WEST SUSSEX COUNTY COUNCIL CONSULTATION

TO:	Arun District Council FAO: Anita Gardner
FROM:	WSCC - Highways Authority
DATE:	24 May 2022
LOCATION:	Land South Of The Littlehampton Academy Fitzalan Road Littlehampton BN17 6ED
SUBJECT:	LU/144/22/DOC Approval of details reserved by condition imposed under ref LU/116/21/PL relating to Condition No 7 - Construction Management Plan.
DATE OF SITE VISIT:	n/a
RECOMMENDATION:	Advice
S106 CONTRIBUTION TOTAL:	n/a

Client	Bo'lyok		
Project	Land to the south of Ullingham Academy		
Drawing No	Vehicle Sweep Path Assessment	BROHUIS 3-AXLE DELIVERY	
Drawing No.	4806	Rev.	R03
Issue	As Shown	Drawn by	DLH
		Checked by	SAJ
		Approved by	A

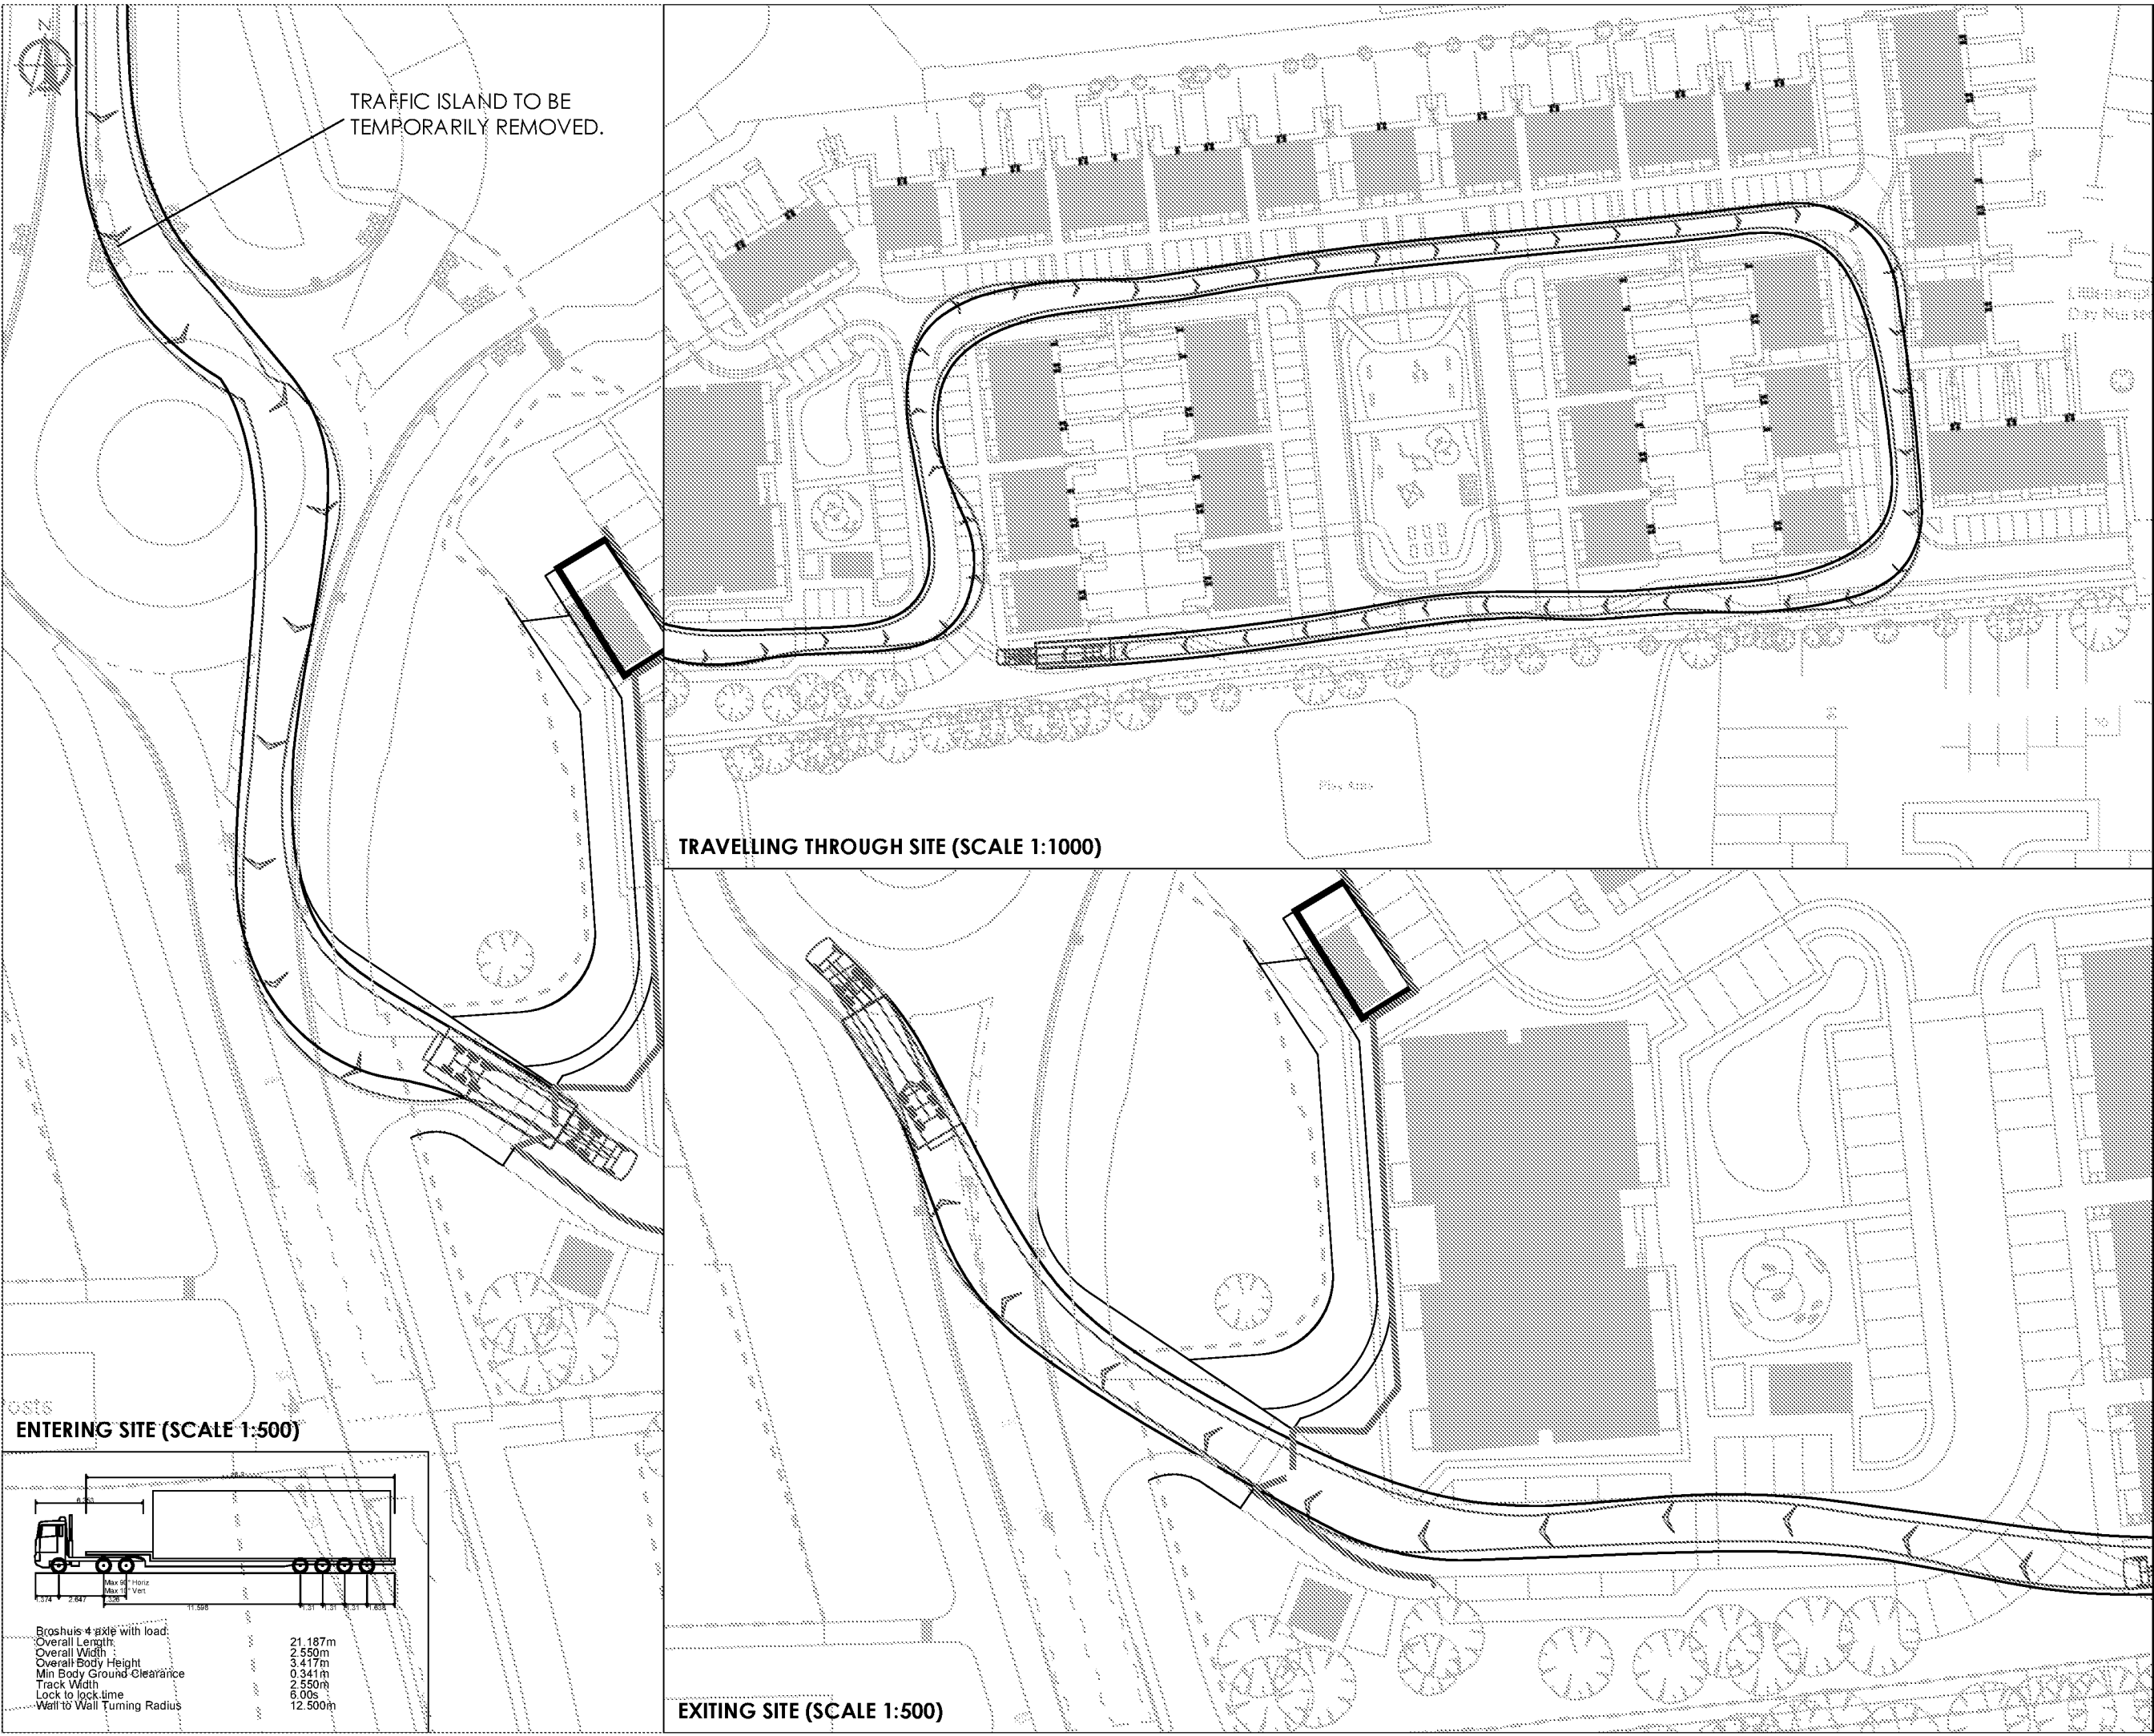
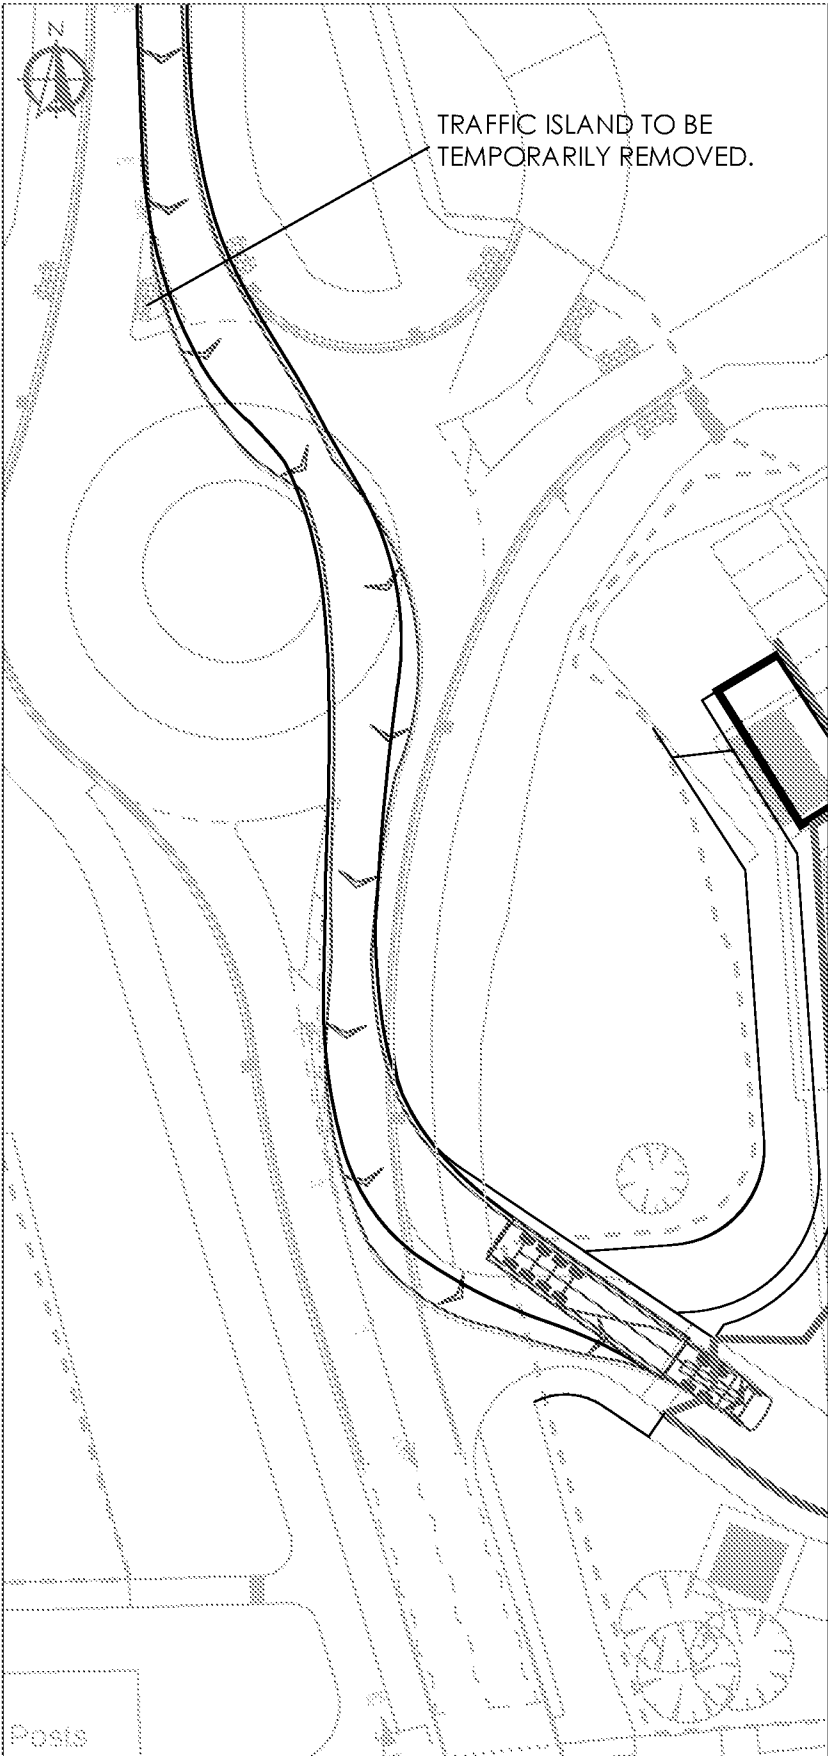
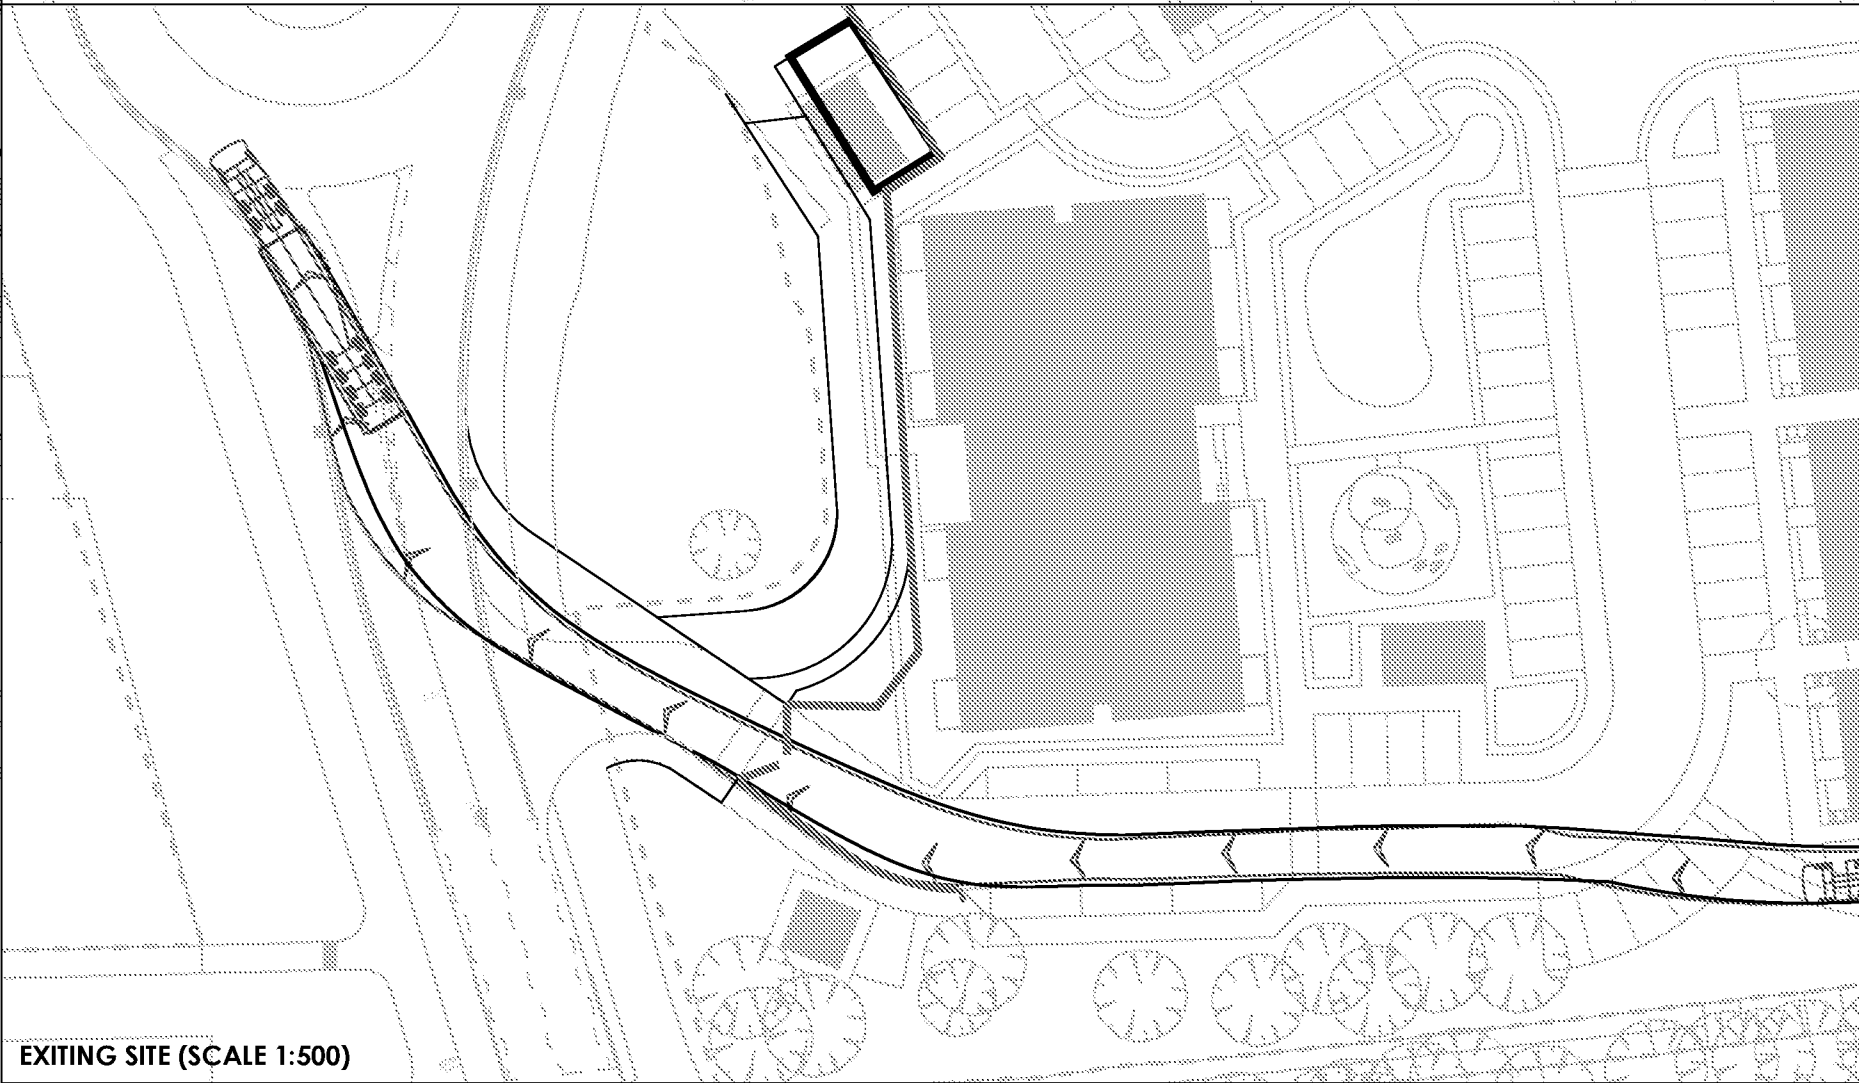
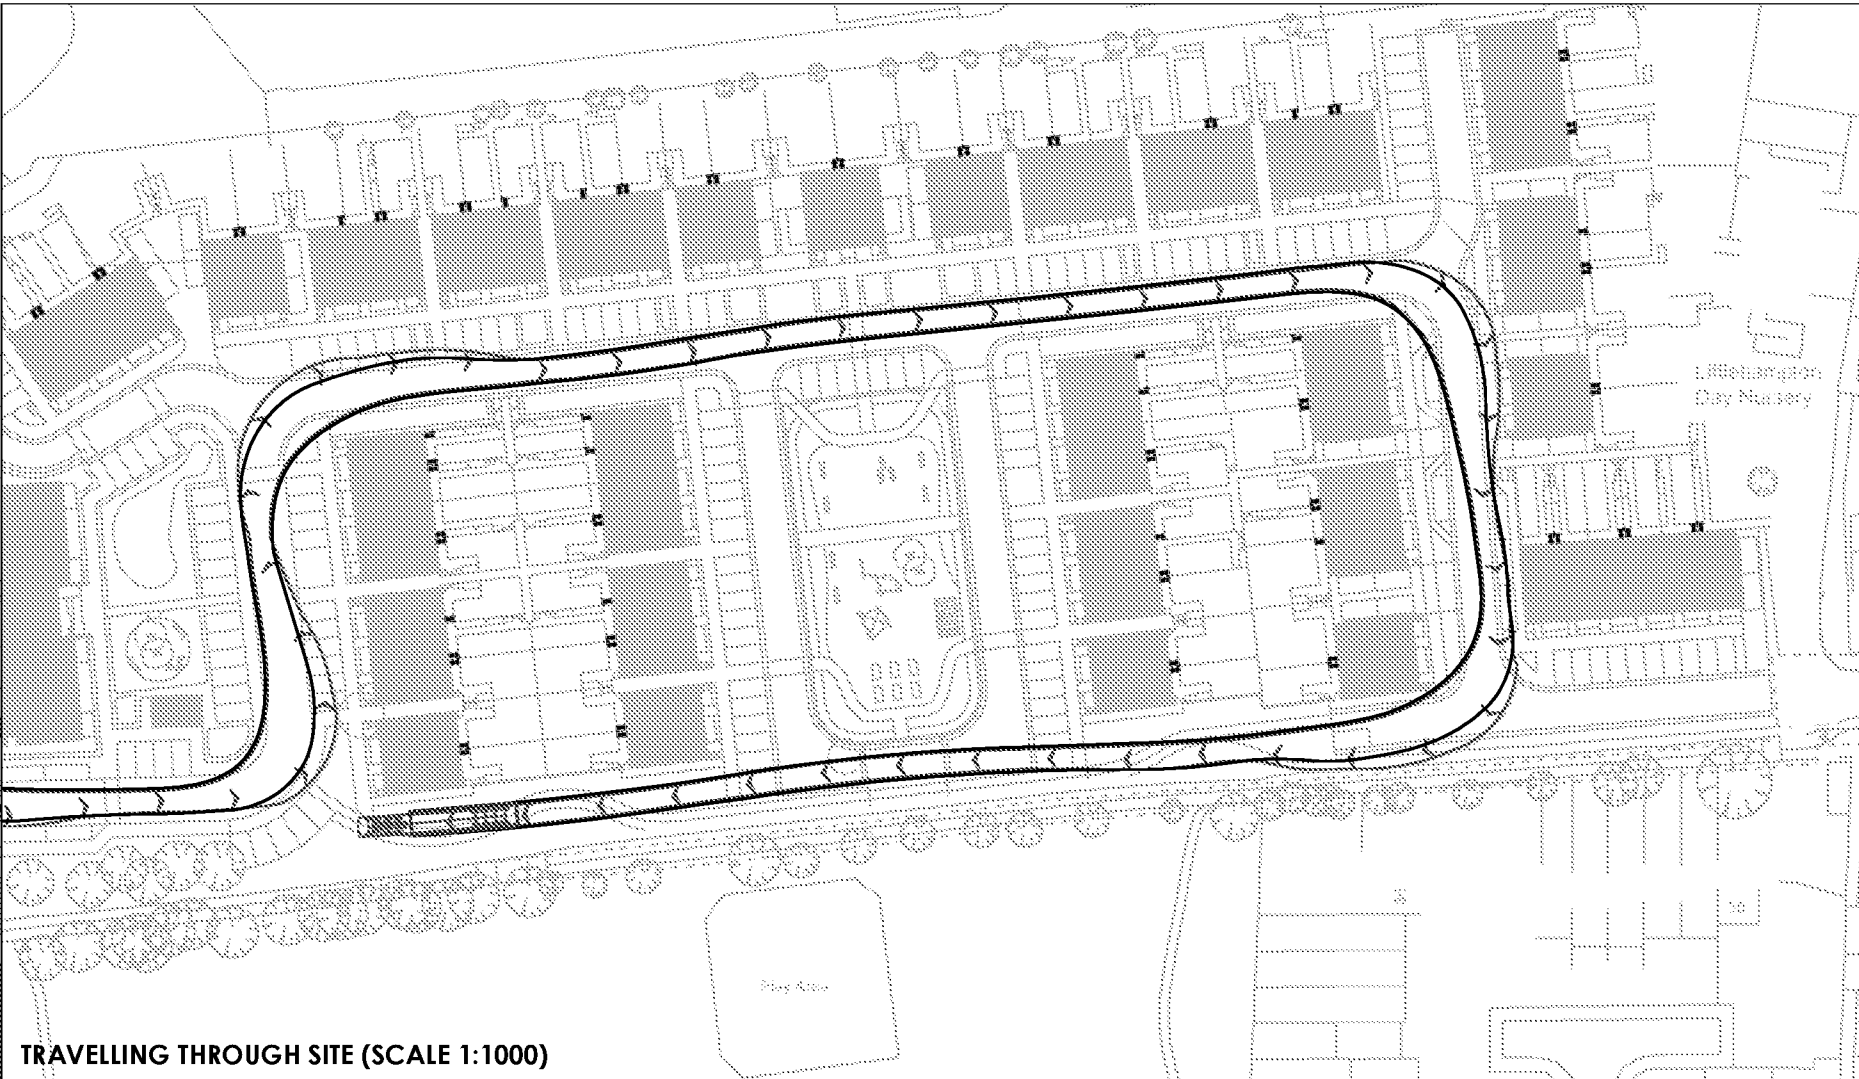
The proposed routing strategy covered within appendix D is noted. It's recognised that the tracking drawings are based upon the earlier revision of the routing strategy that required vehicles to arrive from the south and u-turn at the Littlehampton Academy Roundabout. This manoeuvre is no longer necessary given that vehicles can arrive and depart from the A259 to the north via the Fitzalan Road extension before turning left into the development and then exit northbound in the same way. It would still be requested that the tracking drawings are updated to ensure a vehicle can arrive from the north as the tracking available appears very tight.

It's also noted based on the vehicle specifications included that the design vehicle used on the tracking is shorter than the longest potential vehicle that might be used. The tracking should be suitably updated to reflect the longest design vehicle.

APPENDIX C

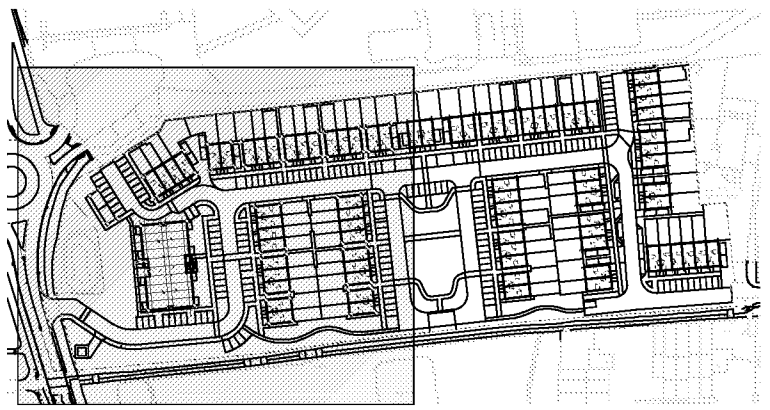
The only other matter requiring further attention at this stage is confirmation in terms of the positioning of any wheel cleaning facility (required to prevent debris being tracked onto the public highway) as well as confirmation that no further Construction Environmental Management Plans are proposed (as suggested in 7.3.4).
